Application no: H02/0677/99

Description: Construction of one dwelling

Location: No 8 Plank Drove
Crowland
Lincs

NOTICE OF ACCEPTANCE OF AMENDMENT

AMENDED PLAN
Ref. A/1

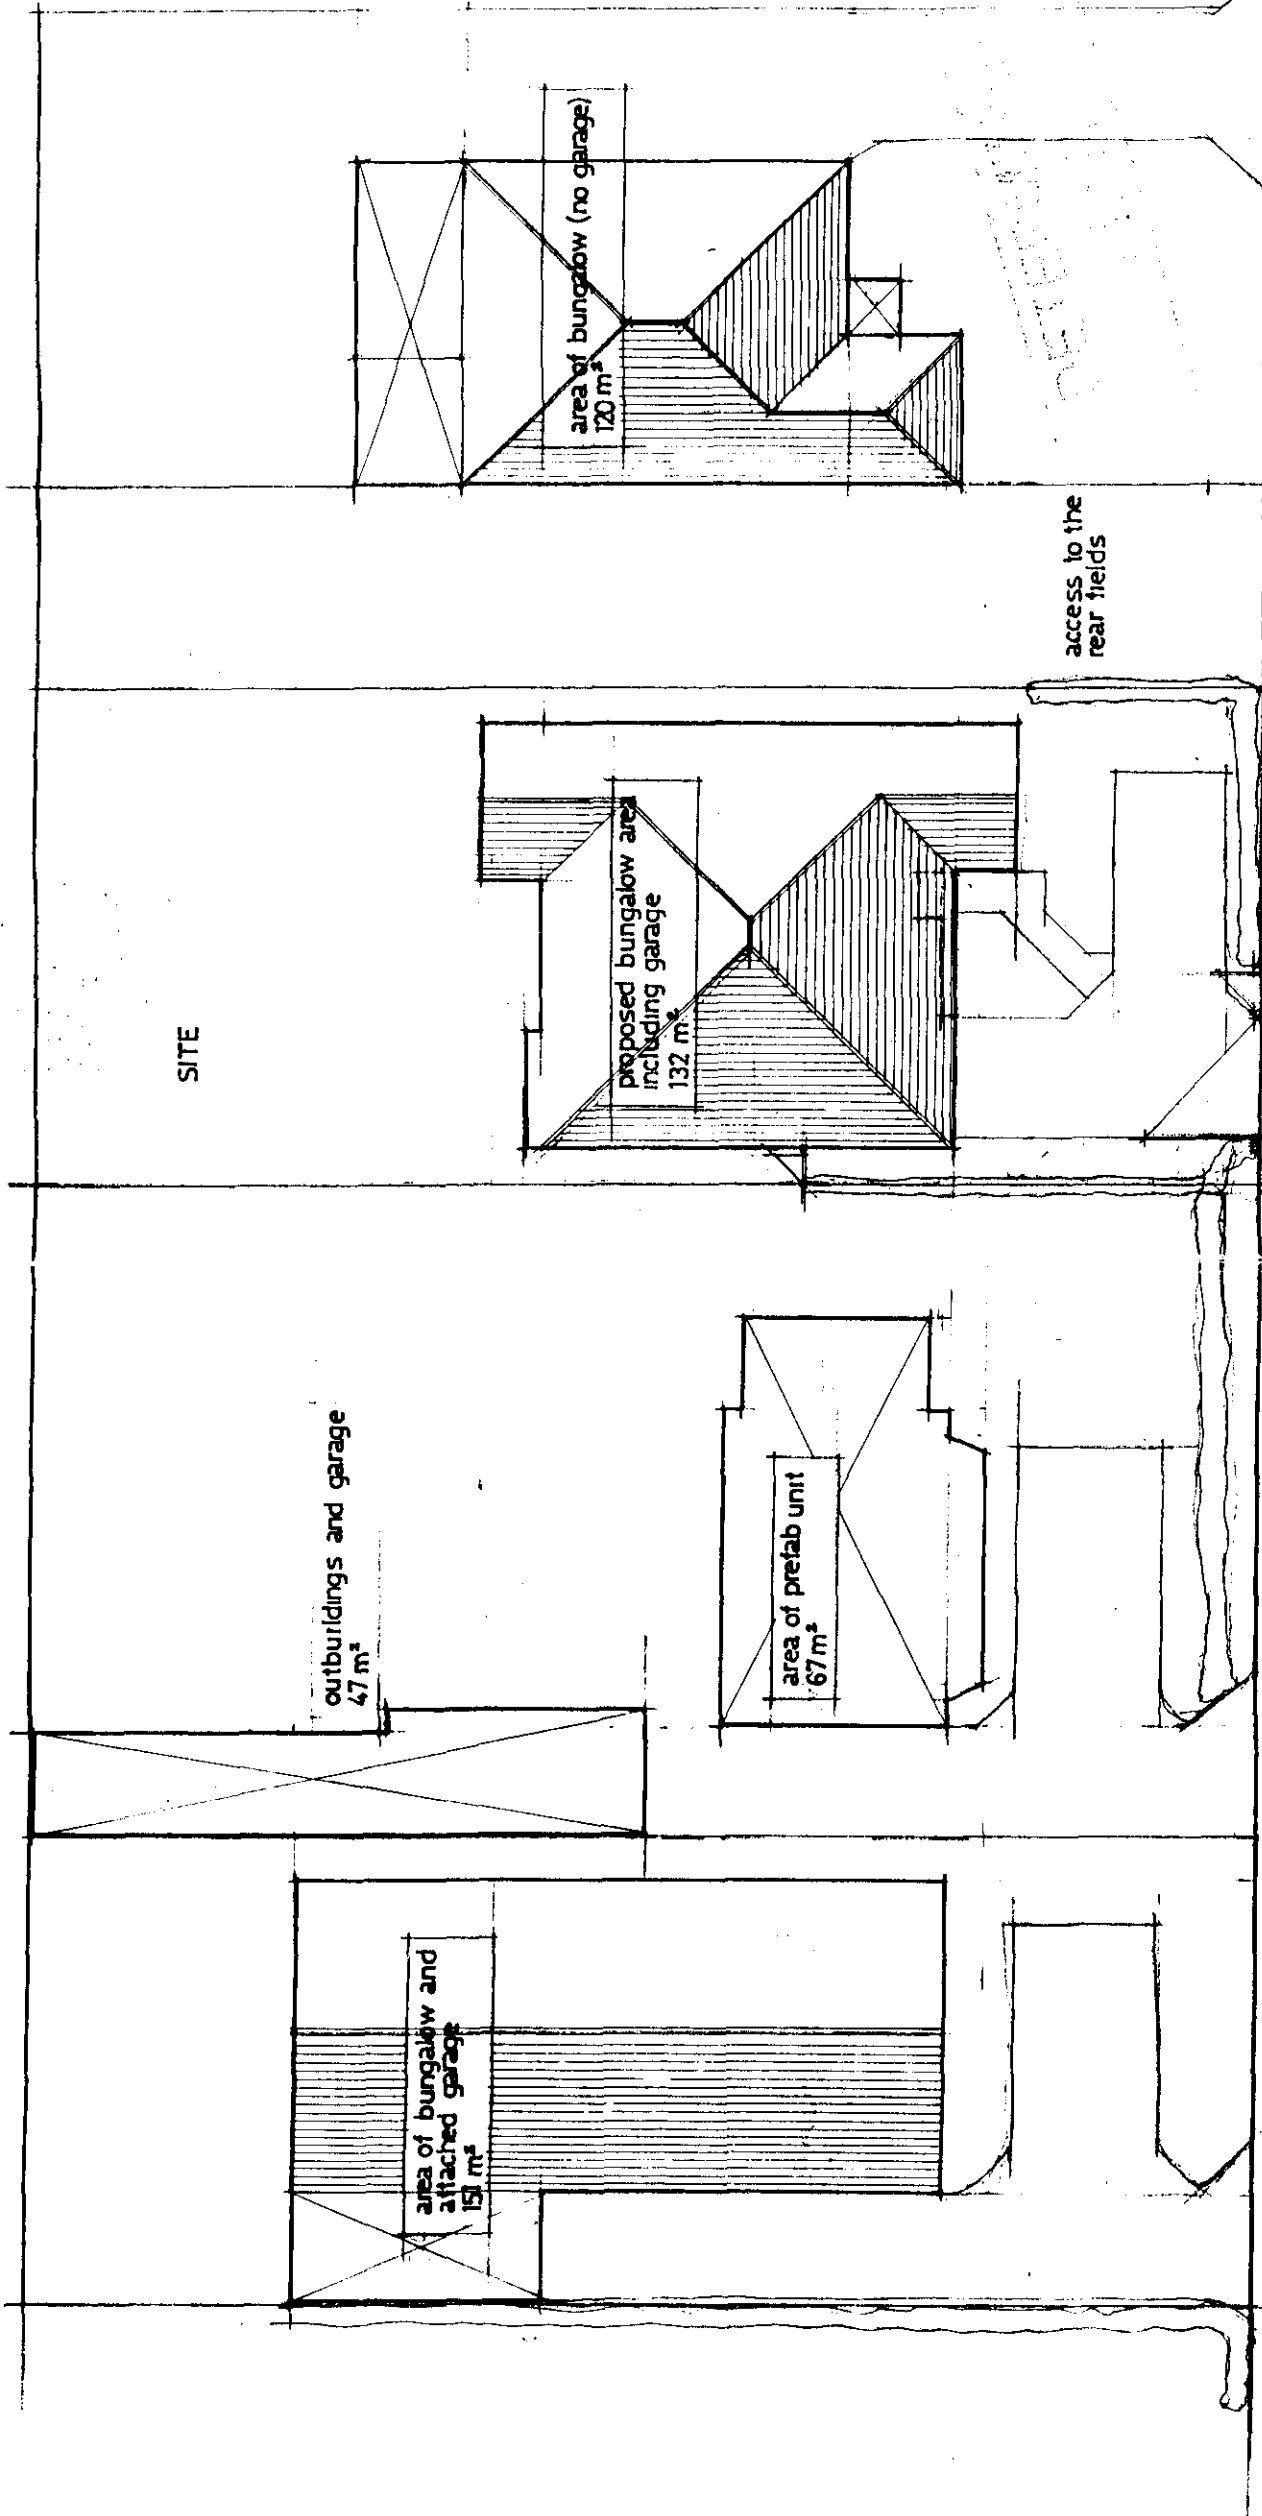
Amendment: Set whole dwelling back a further one metre from front
boundary

SET NEW DWELLING BACK A
FURTHER ONE METRE FROM
FEINT BOUNDARY

The amended details submitted in respect of the above proposal have now been considered and there are no objections to the amendment being implemented to the extent described above.

AMENDED PLAN

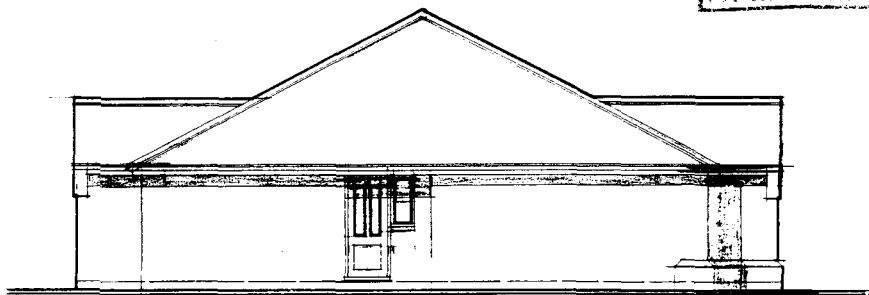
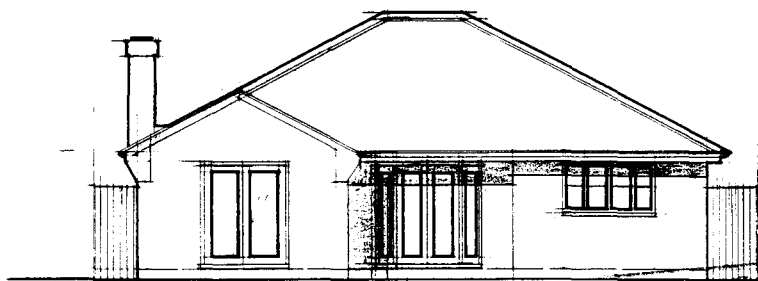
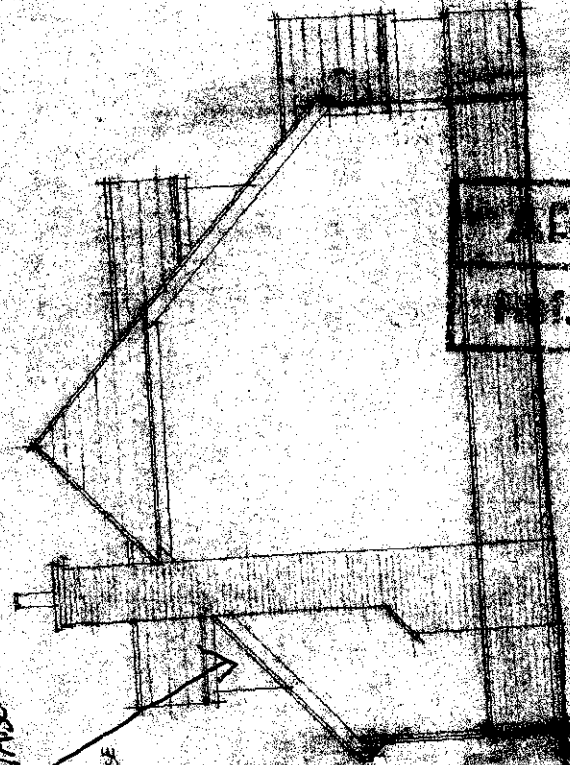
Amendment: Dormer Cheeks and Gables: Fix 'Waney' edge timber
cladding as opposed to render.

DORMER CHEEKS AND DORMER
GABLES
FIX 'WANEY' EDGE TIMBER
CLADDING AS OPPOSED
TO RENDER

The amended details submitted in respect of the above proposal have now been considered and there are no objections to the amendment being implemented to the extent described above.

Ref. A2

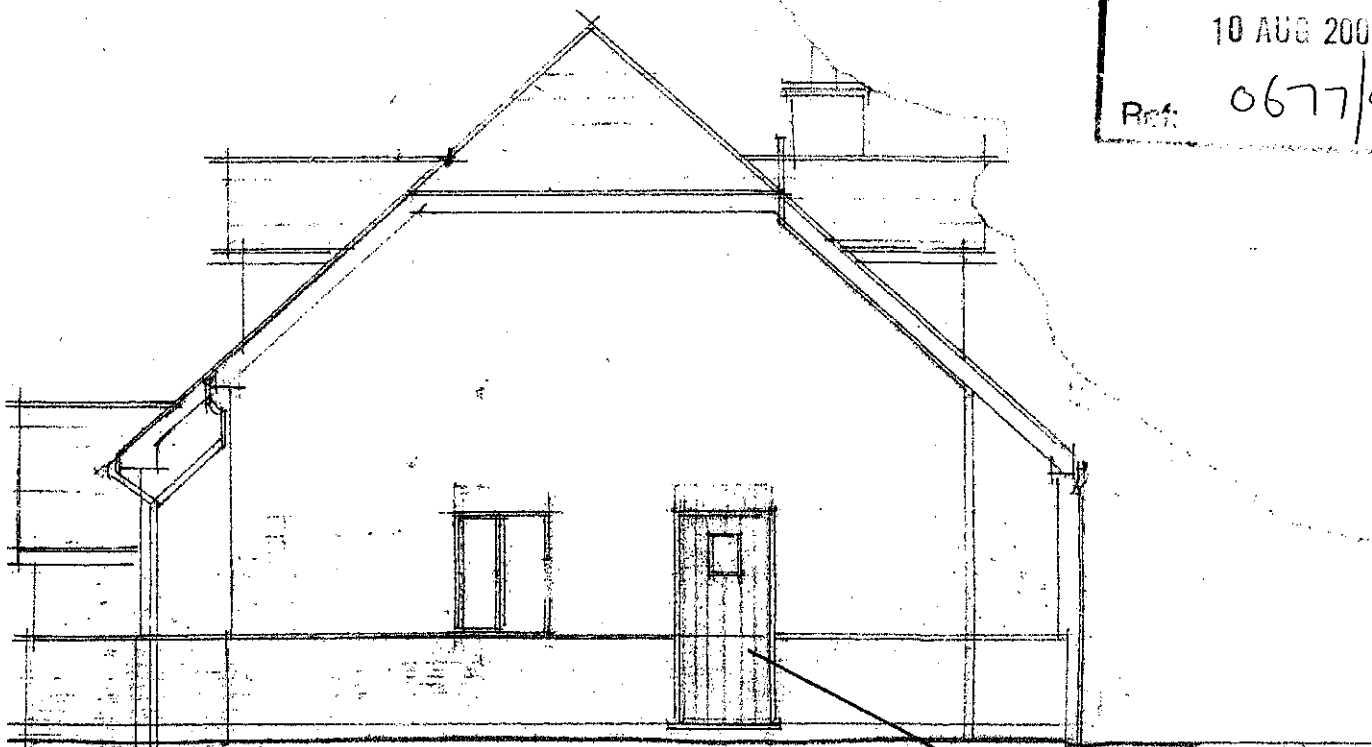
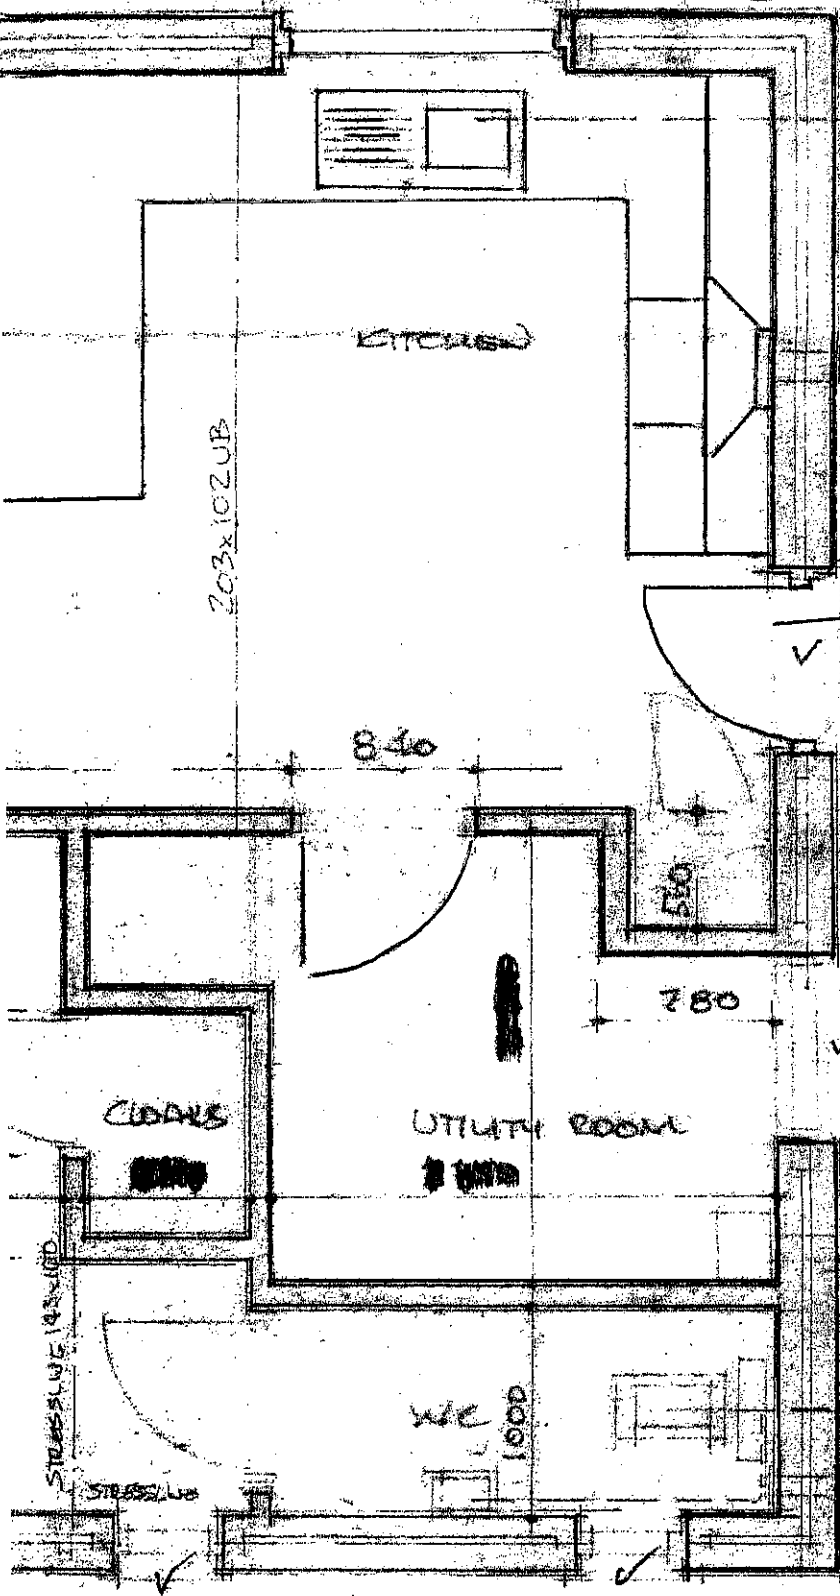
Amendment: Move kitchen external doorway from rear elevation to side
elevation

*move kitchen external doorway
from rear elevation to side elevation.*

*Along Mr Warner the rear elevation I'll
also change - that door for kitchen moves
from rear to side. Therefore only a window in
rear elevation for kitchen.*

change window to door.

The amended details submitted in respect of the above proposal have now been considered and there are no objections to the amendment being implemented to the extent described above.
